## Questions posed to the IP's from the ExA

RP Type

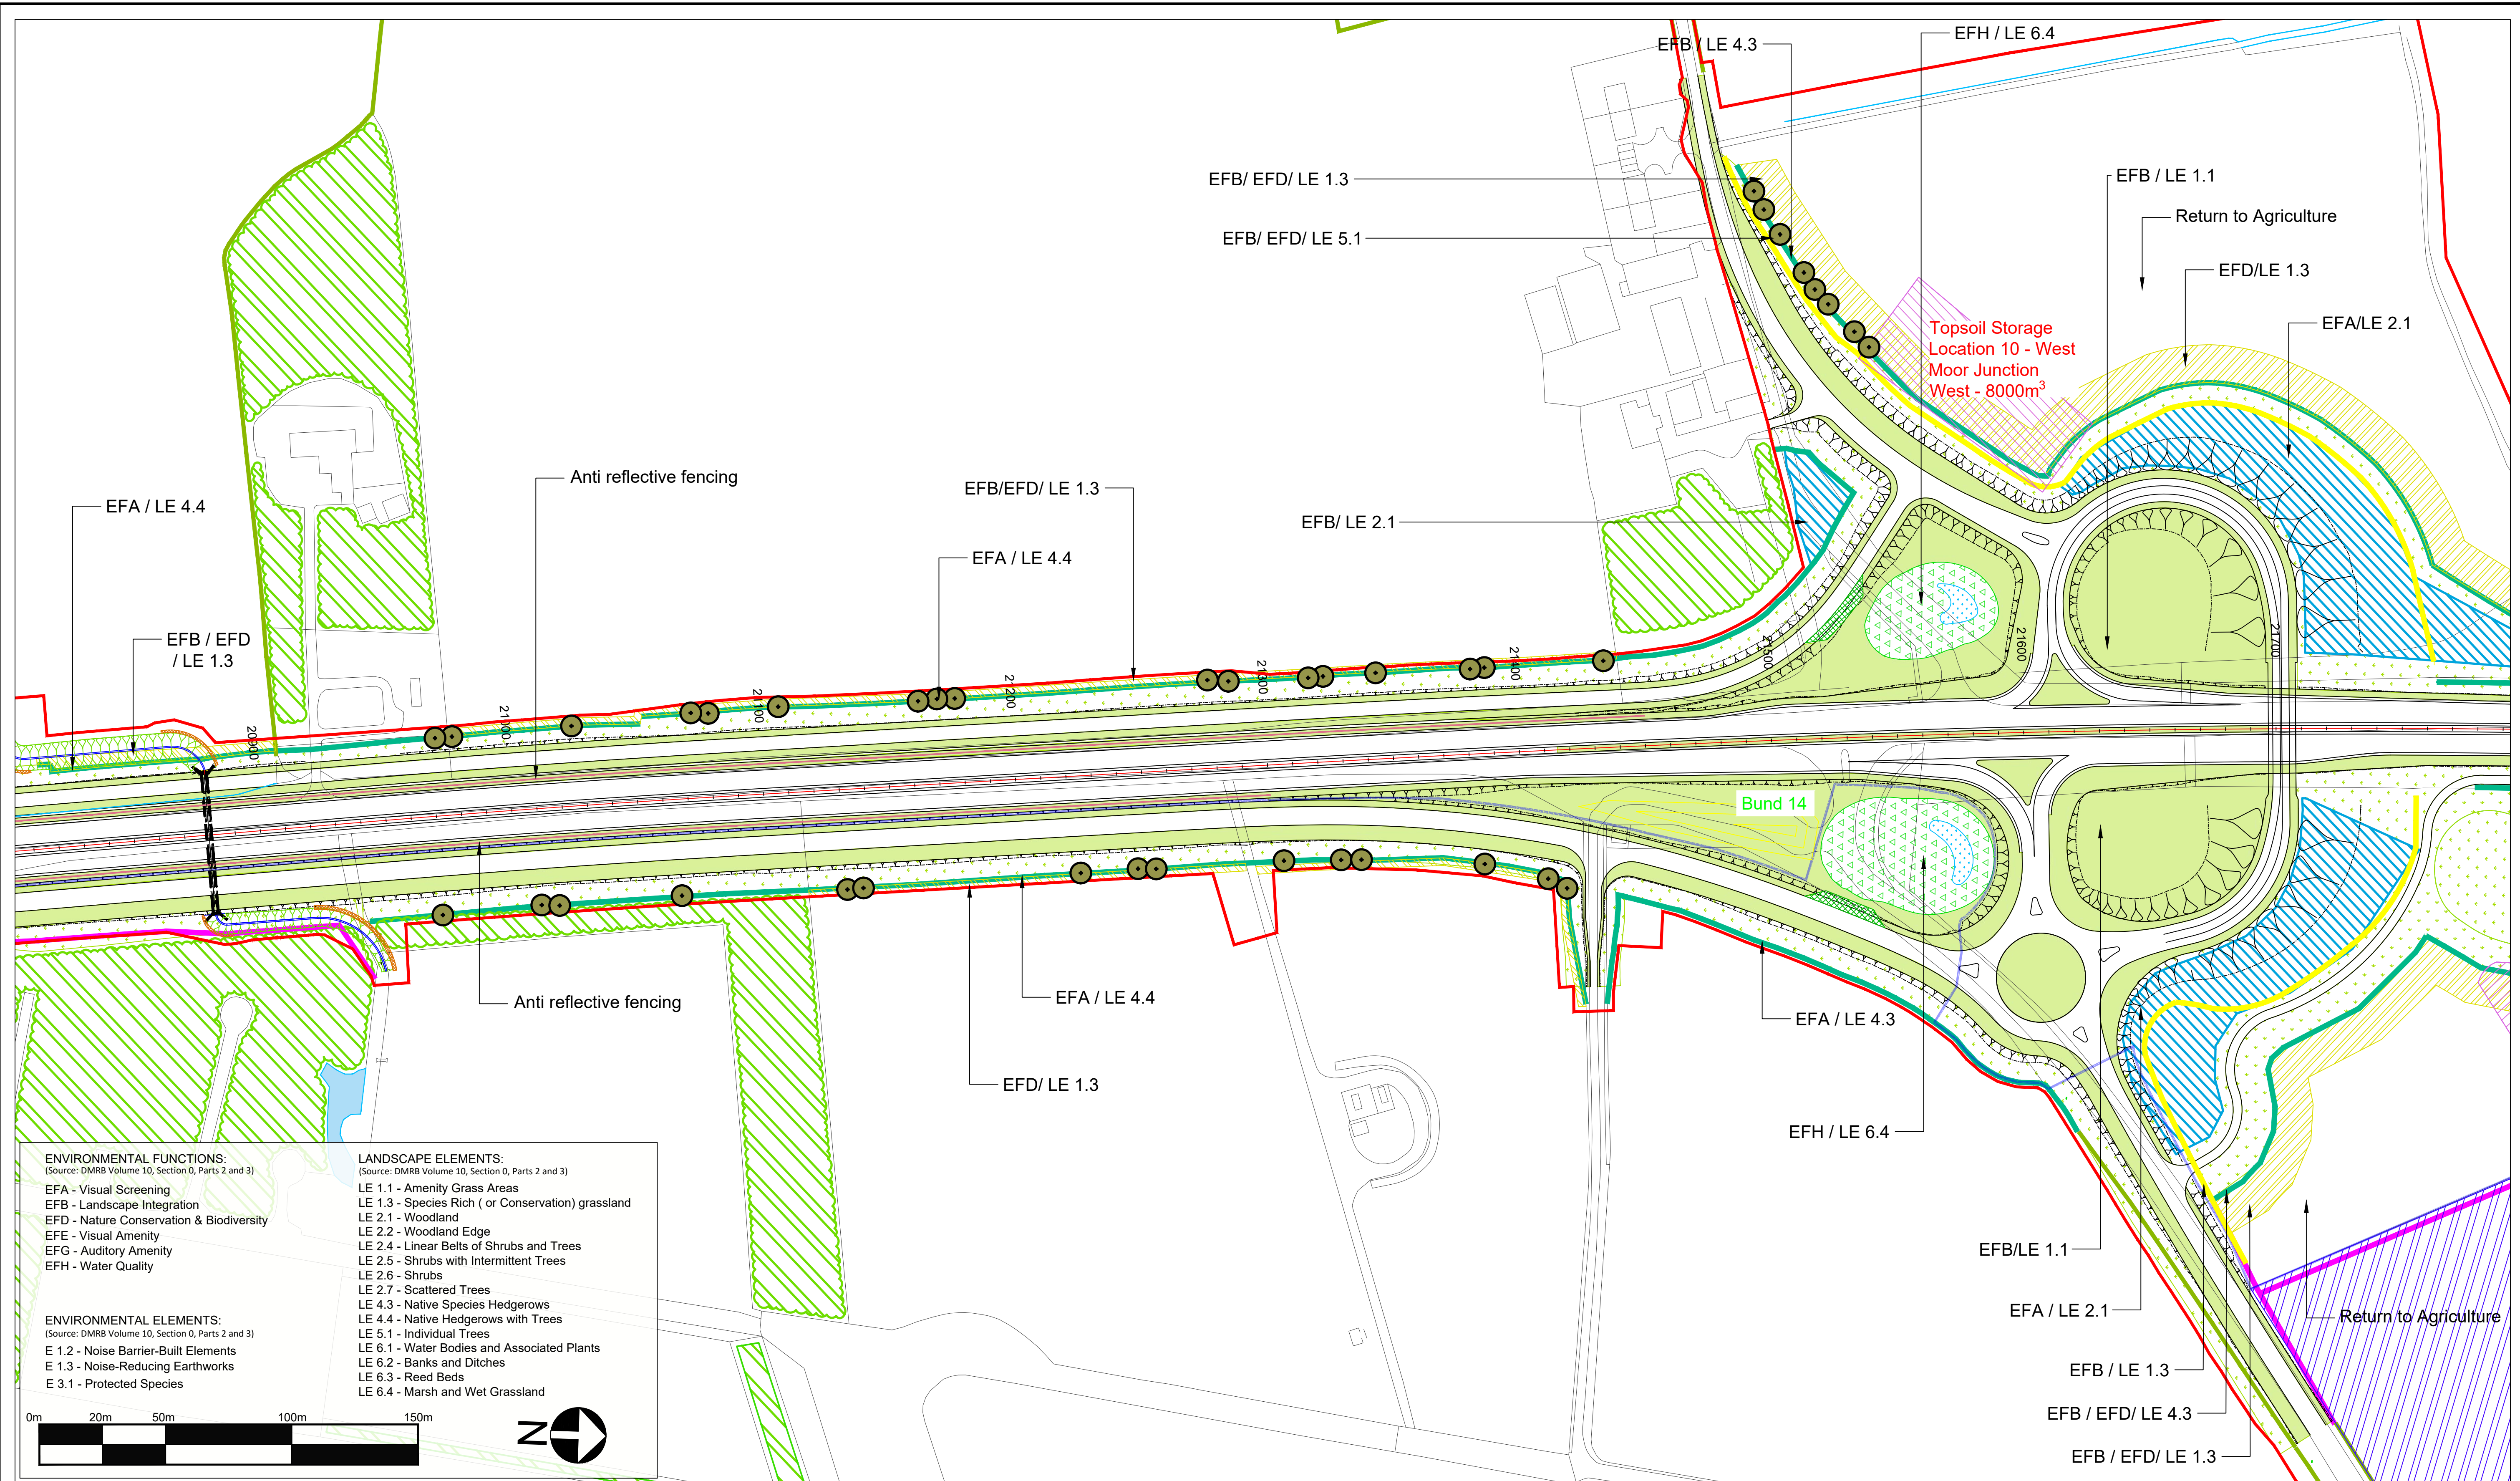
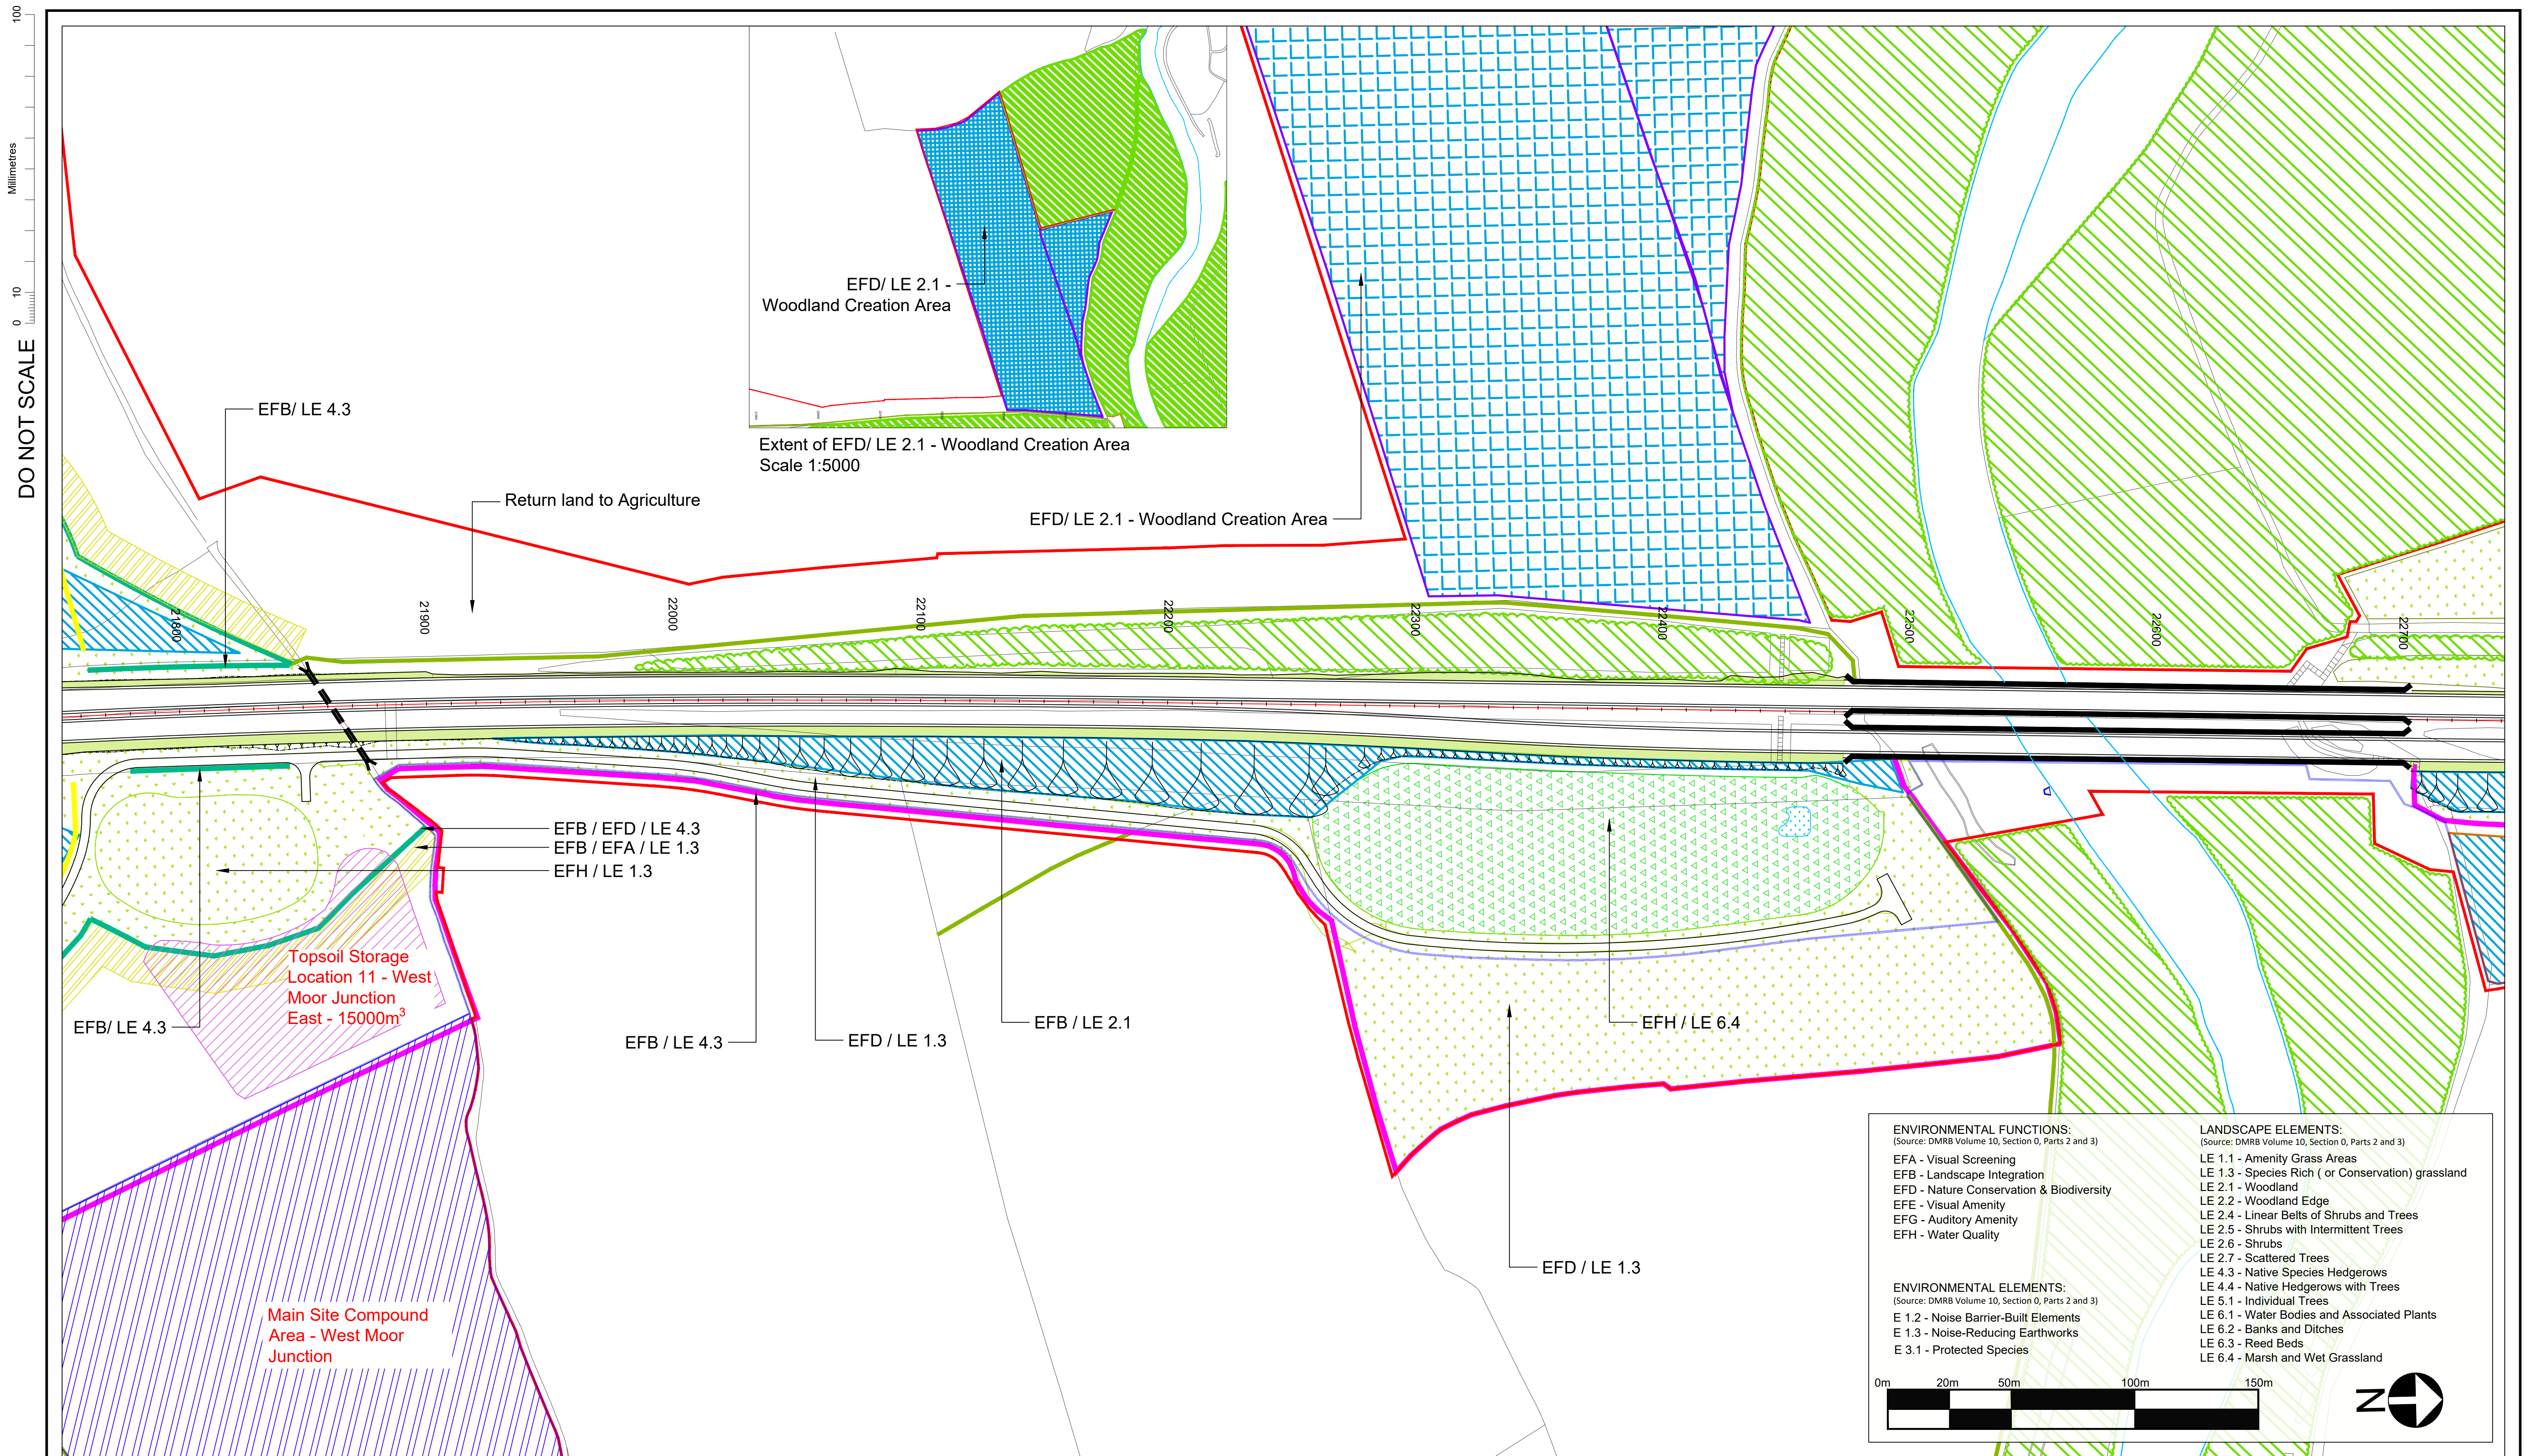
1. Whilst it is positive to see the detail of the landscape mitigation principles, I am struggling to see this approach reflected in the actual plans detailed in APP-095.
2. As I have a number of outstanding queries relating to the Masterplan, I would welcome further detail and context provided by a landscape and ecological management plan.
3. As the current plans involve major detrimental changes to the landscape that I currently enjoy I have raised a number of concerns and queries with the Applicant on this topic in May 2020 which remain outstanding. I am hopeful that a scheduled meeting with the Applicant will help answer the queries.

1. Unfortunately, the Landscape Mitigation Masterplan shown in APP-095 is a major source of frustration and disappointment as I believe that it falls well short of what should be achieved to address landscape and ecological features.

2. In considering my property, as an example, the plans involve major changes to the to a picturesque landscape on all sides of the property. The current outlook from my property which includes mature woodlands and a pleasant tree lined avenue is to be replaced with 7 lanes of tarmac including a layby and access roads. The Landscape Masterplan offers very little mitigation to offset the detriment to visual effect. The sense of frustration is further exacerbated when the impact on the landscape visual is categorised as being slight.

1. As the plans involve major detrimental changes to the landscape that I currently enjoy I have raised a number of concerns and queries with the Applicant on this topic in May 2020 which remain outstanding. As some of my queries relate to the use of keys in the plans, I would welcome any additional information to help my understanding.
